Our Ref: 24/00879/HFUL  
Your Ref: TAB786 - Gables Close (64)

Proposal: Extension of existing wheelchair ramp to include the side and rear and the addition of a handrail, alterations of windows to front, side and rear elevations and removal of chimney.

Site address: 64 Gables Close Meldreth Cambridgeshire SG8 6LQ

**Drawing Title**  
 Proposed Site Location Plan

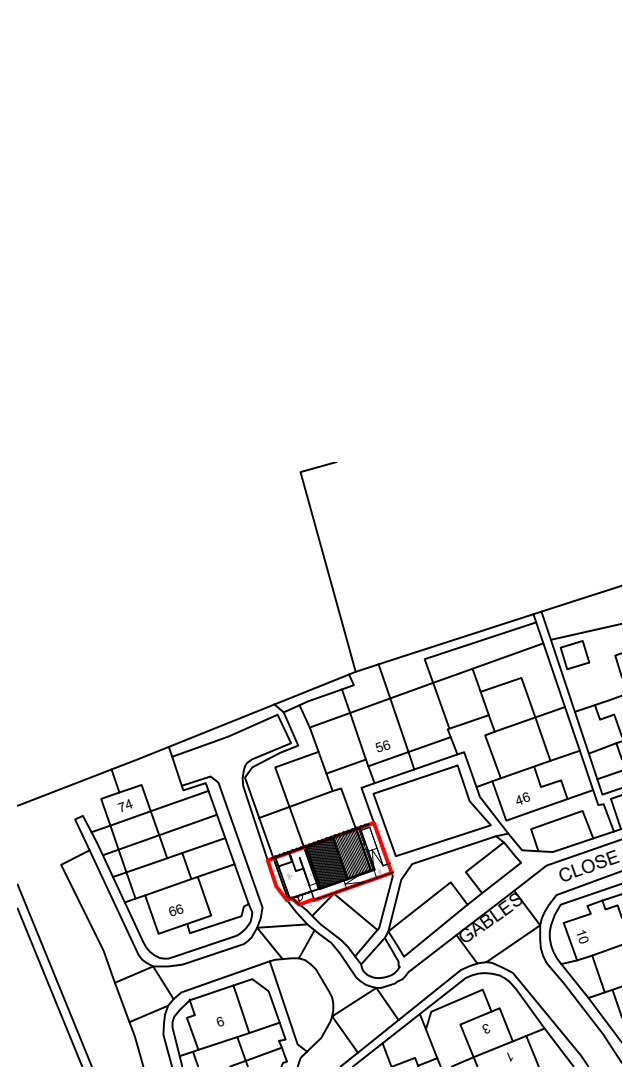
1. Please confirm in writing whether you agree with the above amended description.
2. The proposed location/site plans show an overhang with the adjoining property. Please could you remove the overhang from the drawing if it is not part of the proposals.
